Our ref: TH/30155
Planning portal ref: PP-12924080

APPLICATION FOR A NON-MATERIAL AMENDMENT TO VARY CONDITIONS 2 & 20 OF PLANNING PERMISSION 23/01621/FUL (*DEMOLITION OF EXISTING SCHOOL BUILDINGS AND ERECTION OF REPLACEMENT SCHOOL BUILDINGS WITH ASSOCIATED PARKING AND LANDSCAPING TO INCLUDE SITING OF TWO TEMPORARY CLASSROOM BUILDINGS DURING CONSTRUCTION*) AT ORCHARDS ACADEMY, ST MARY'S ROAD, SWANLEY, KENT, BR8 7TE.

Please find enclosed an application for a Non-Material Amendment ('NMA') to the above permission on behalf of The Kemnal Academies Trust, in relation to Conditions 2 (approved plans) and 20 (Tree Protection Plan).

1 Tree Protection Plan
Scale: 1:500

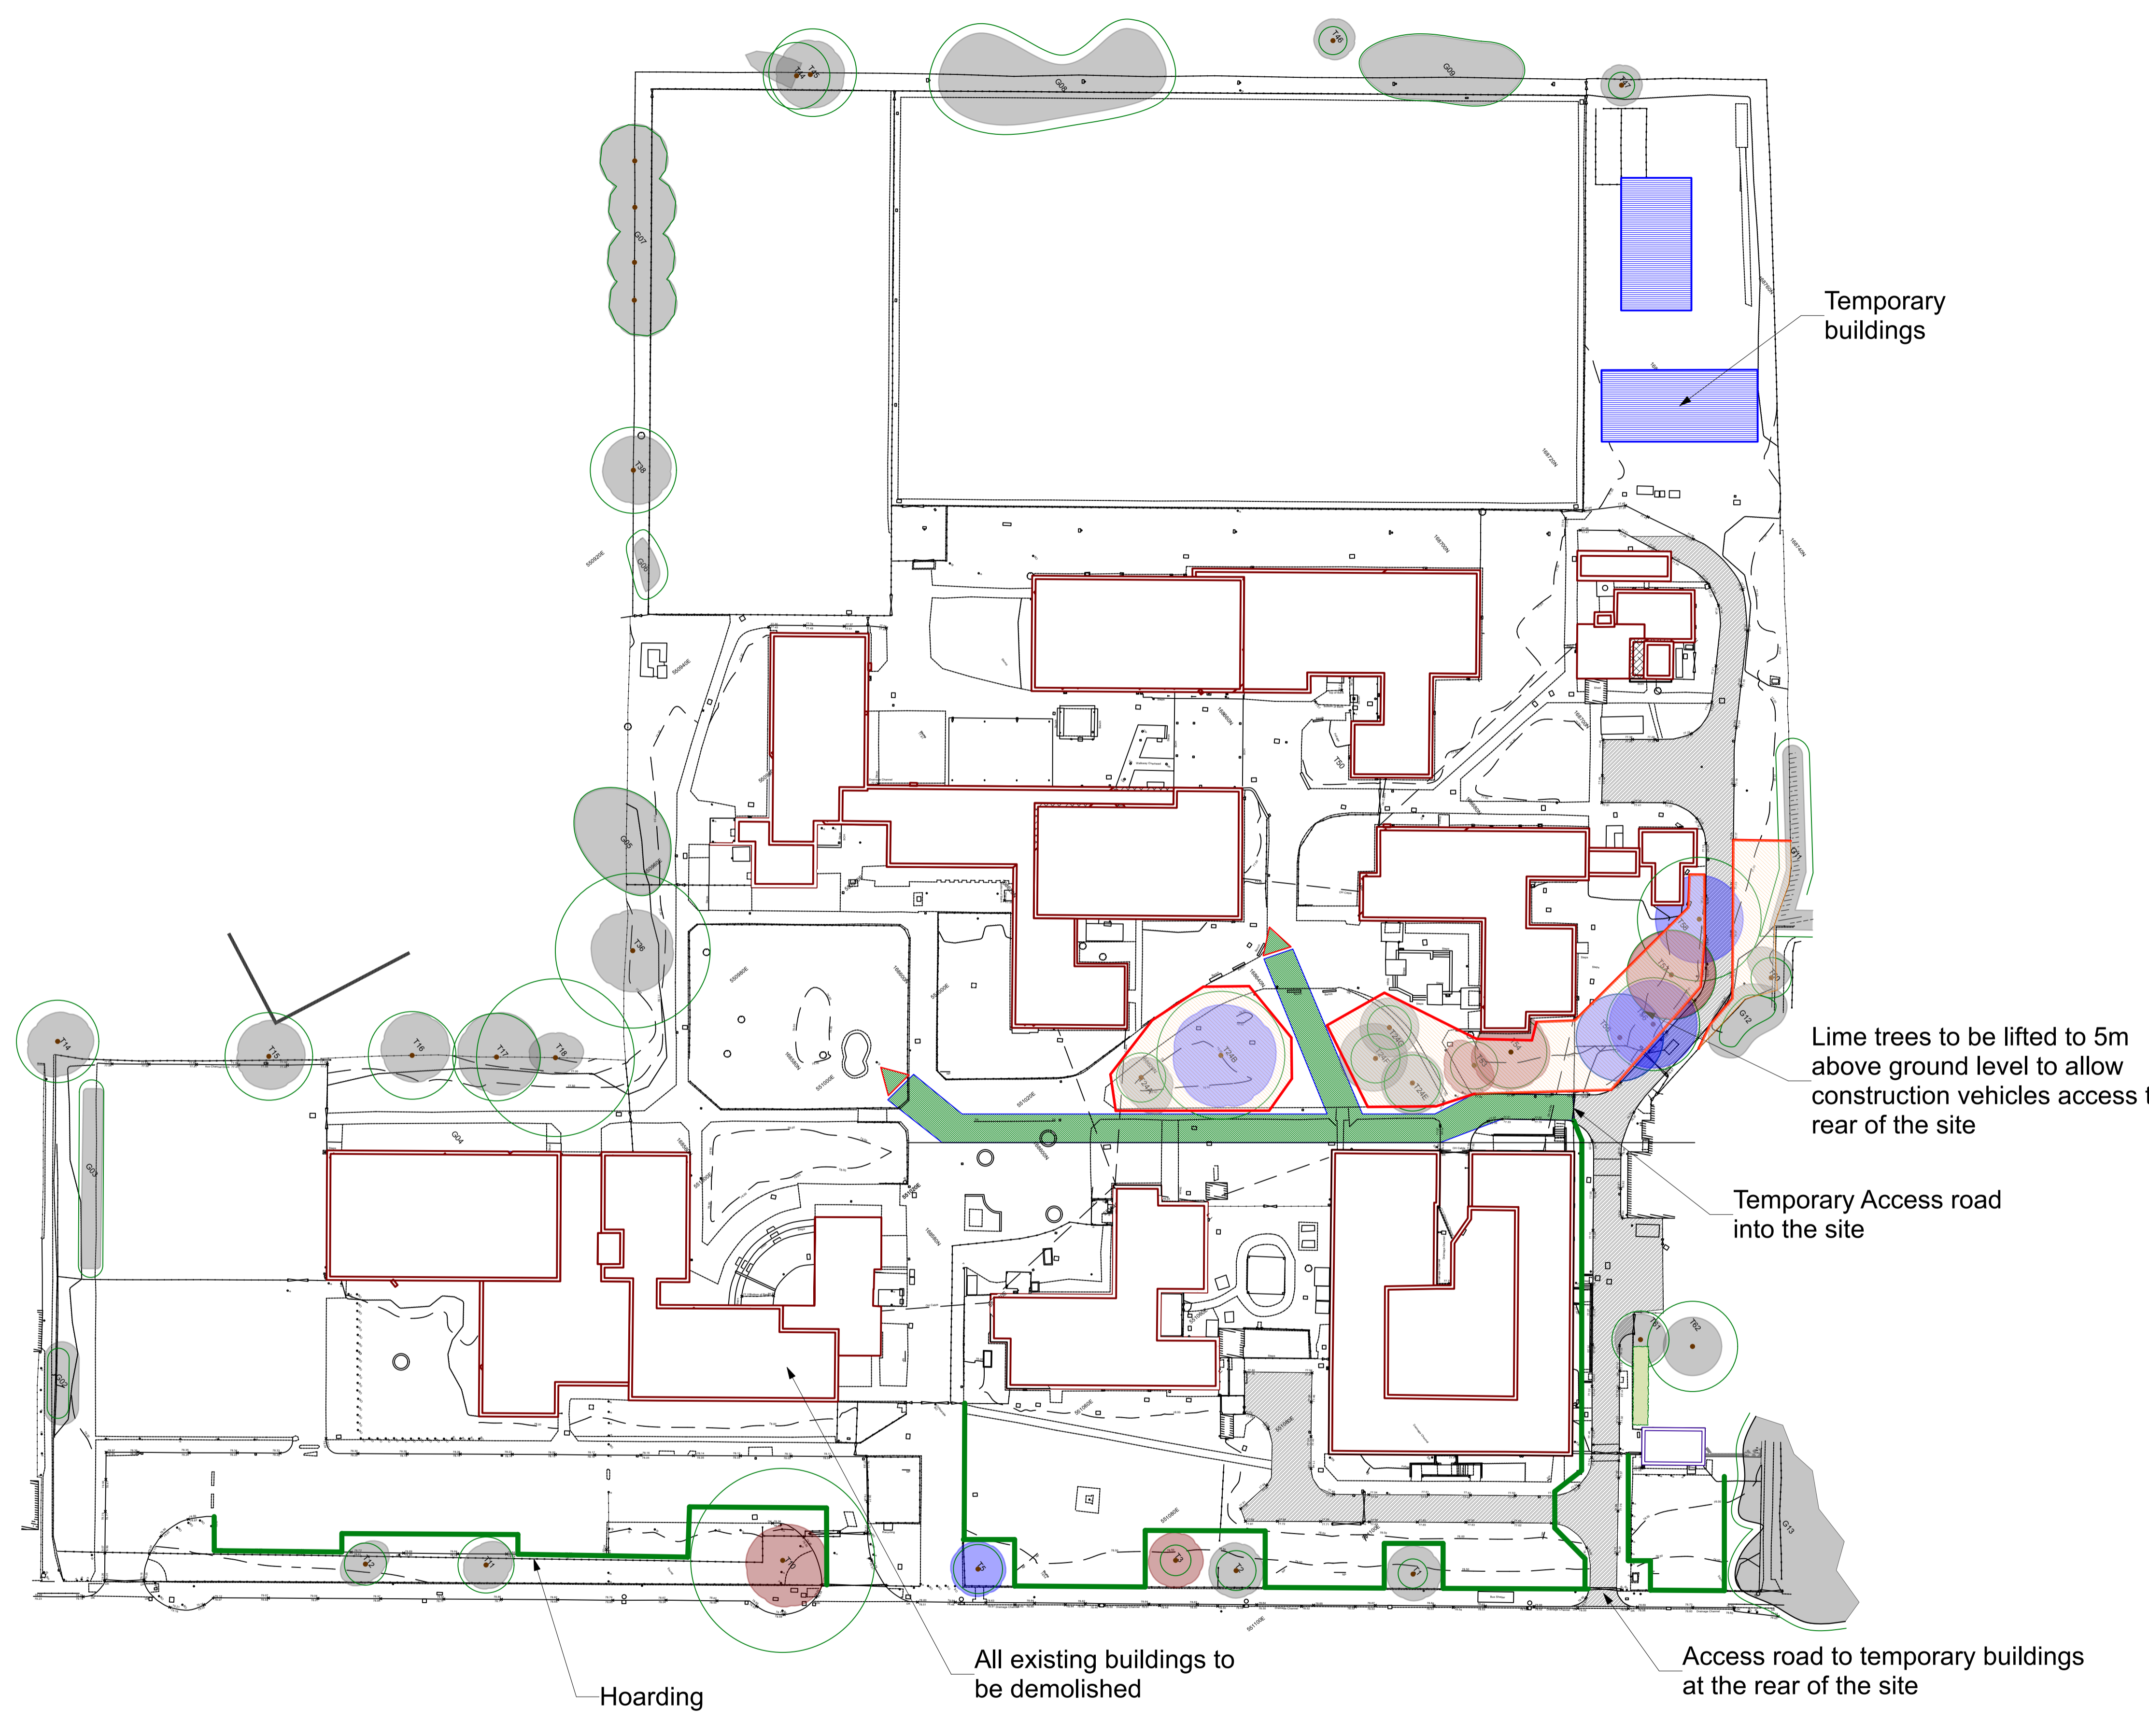
The original Tree Planting Plan (SRP1072-BHL-XX-XX-D-O-0002-Tree Planting Plan) and Tree Protection Plan (SRP1072-BHL-XX-XX-D-O-0003-Tree Protection Plan) were submitted as part of application 23/01621/FUL. These plans conflict with the approved drainage strategy. The proposed drainage strategy runs through the Construction Exclusion Zone (CEZ) of Tree 59 (T59), which would need to be removed in order to carry out the drainage strategy. However, T59 is erroneously shown as present on the original Tree Planting Plan and Tree Protection Plan, despite being clearly shown for removal on the approved landscaping plan (see screenshot below with T59 shown for removal and circled), leading to a conflict between plans. The NMA seeks to amend the original Tree Planting Plan and Tree Protection Plan to show that T59 has been removed from said plans.

'No demolition, site clearance or building operations shall commence on site until tree protection measures have been installed in full accordance with the details shown on the Tree Protection Plan produced by Barry Holdsworth Ltd dated May 2023 (reference SRP1072-BHL-XX-XX-D-O-0003-Tree Protection Plan (No. A)). Within all fenced areas, soil levels shall remain unaltered and the land kept free of vehicles, plant, materials and debris. The protection measures shall remain in situ throughout the duration of the demolition and construction processes.

1 Tree Survey
Scale: 1:500

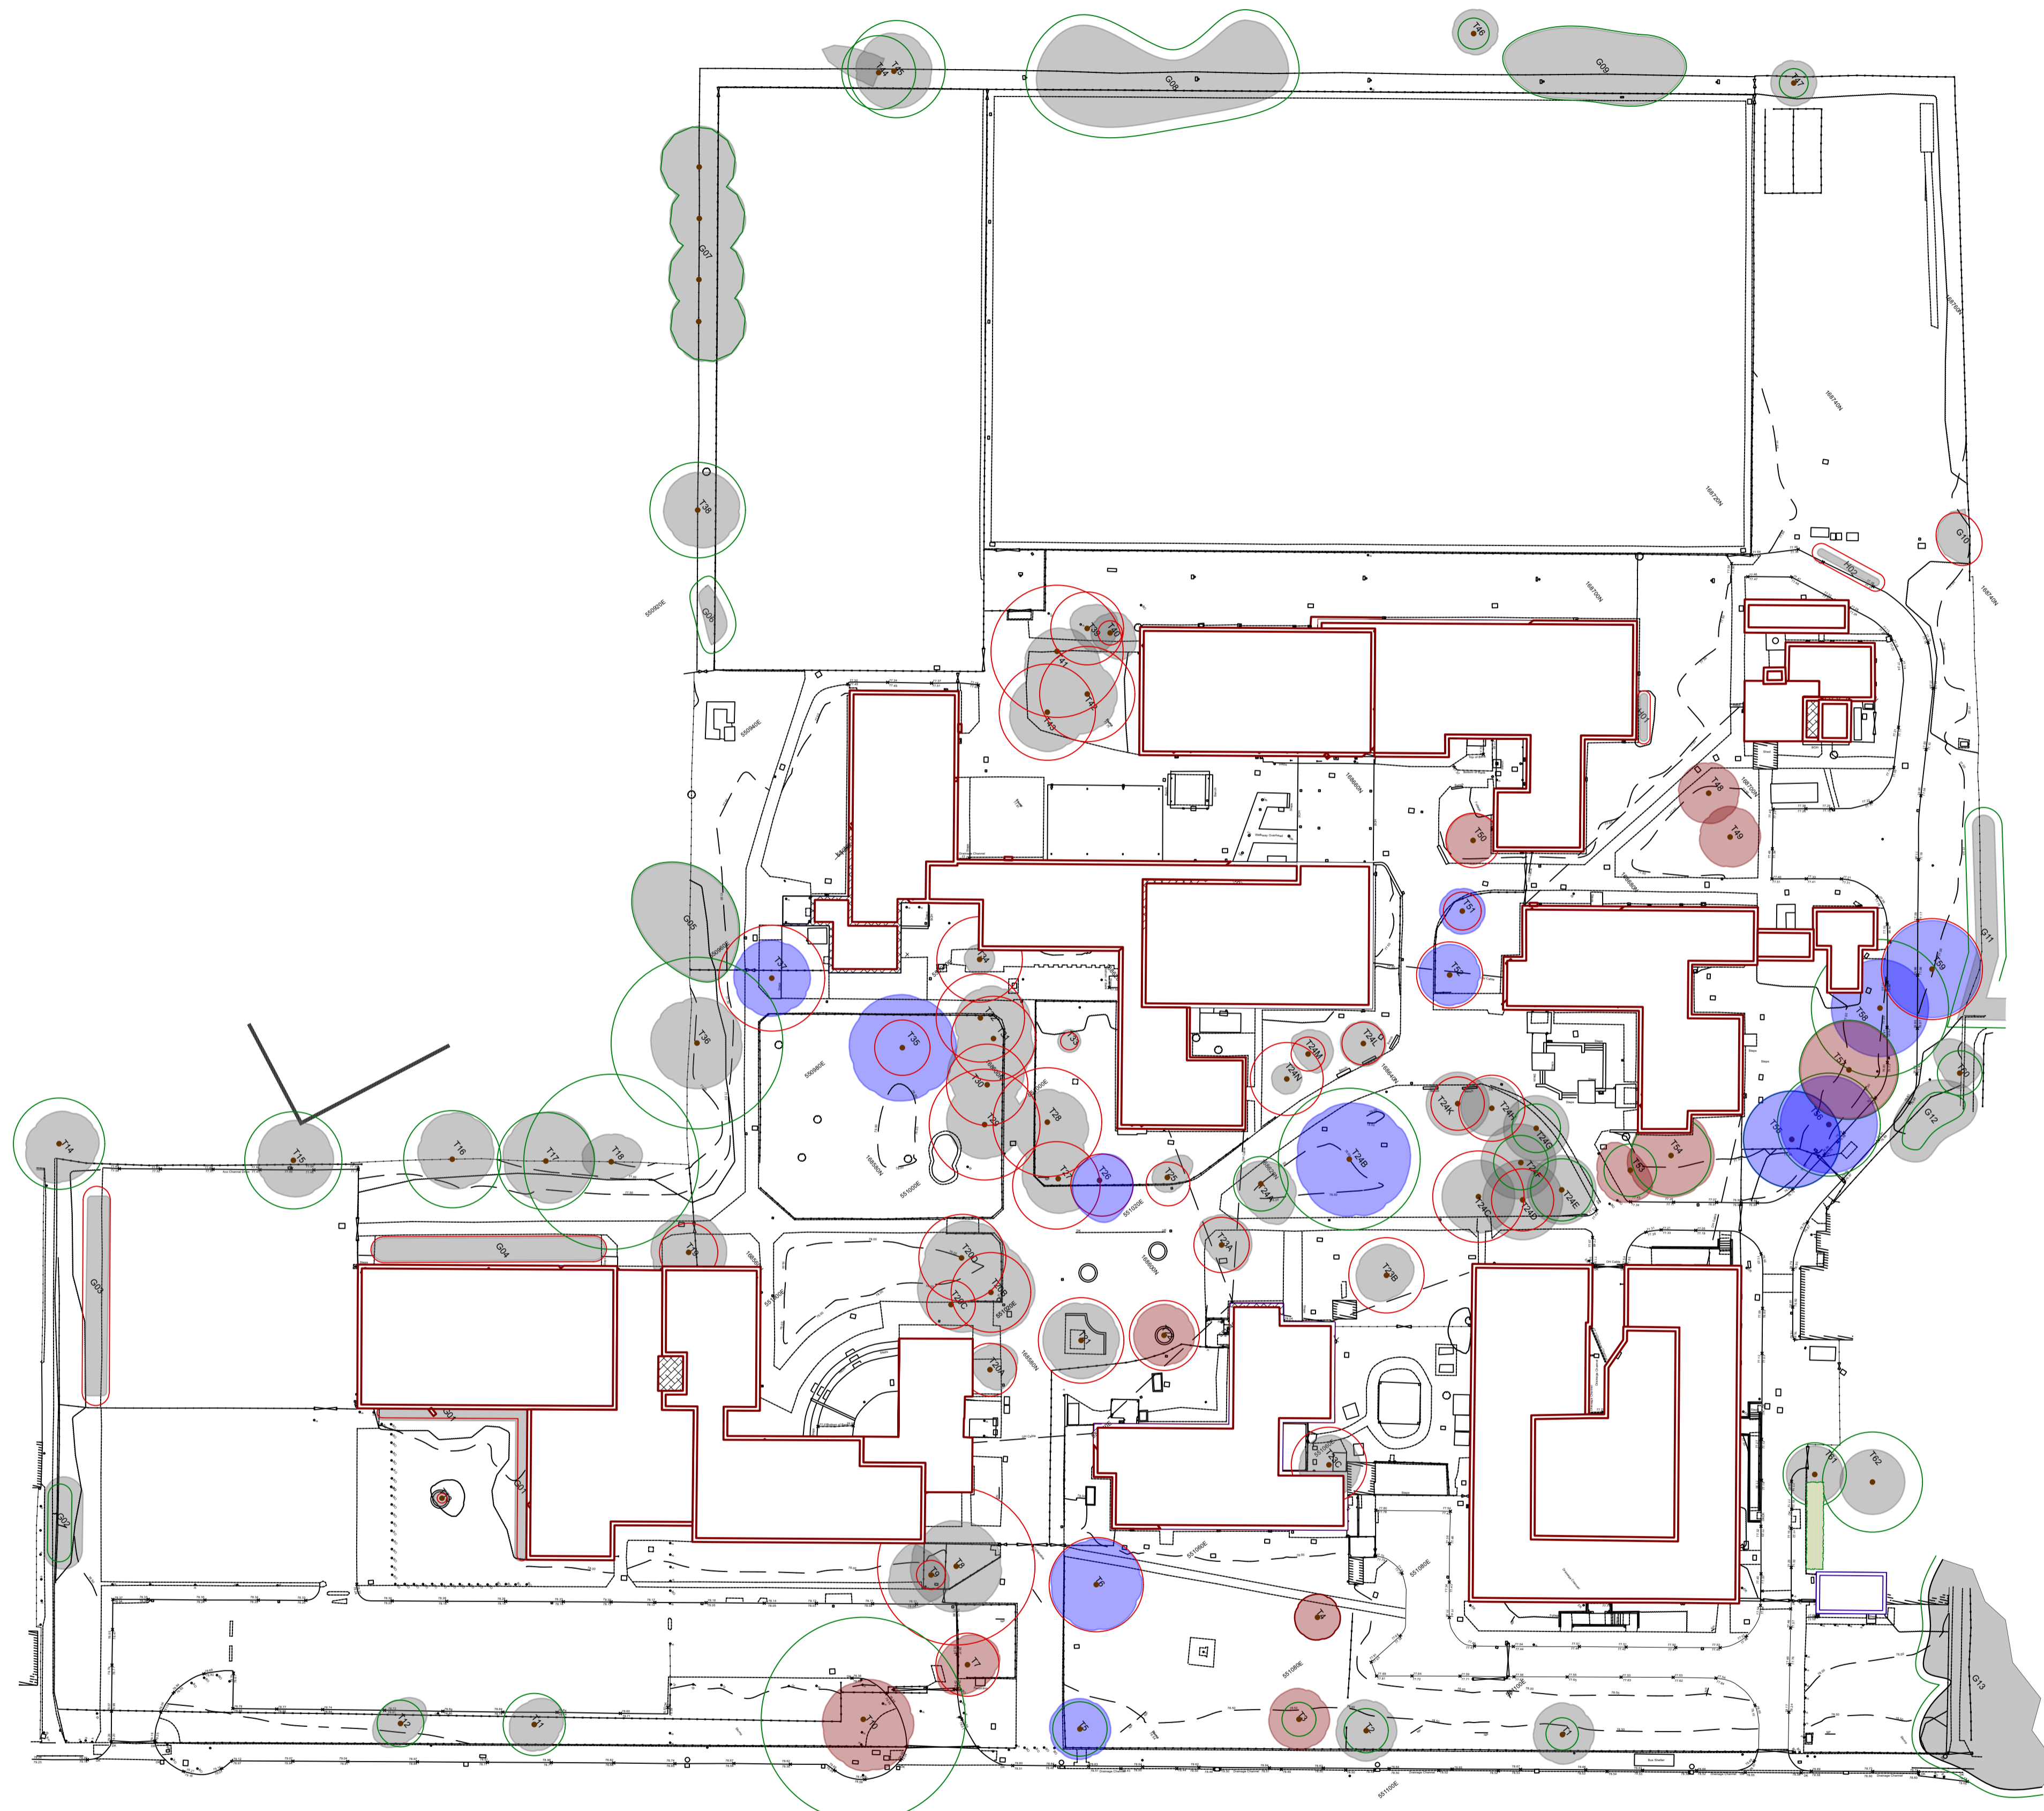
- *SRP1072-BHL-XX-XX-D-O-0002-Tree Planting Plan* is amended to *SRP1072-BHL-XX-XX-D-O-0002-Tree Planting Plan (No. A)*;
- *SRP1072-BH L-XX-XX-D-O-0004-Tree Survey Plan* is amended to *SRP1072-BHL-XX-XX-D-O-0004-Tree Survey Plan (No. A)*.
- *SRP1072-BHL-XX-XX-D-O-0003-Tree Protection Plan* is amended to *SRP1072-BHL-XX-XX-D-O-0003-Tree Protection Plan (No. A)*.
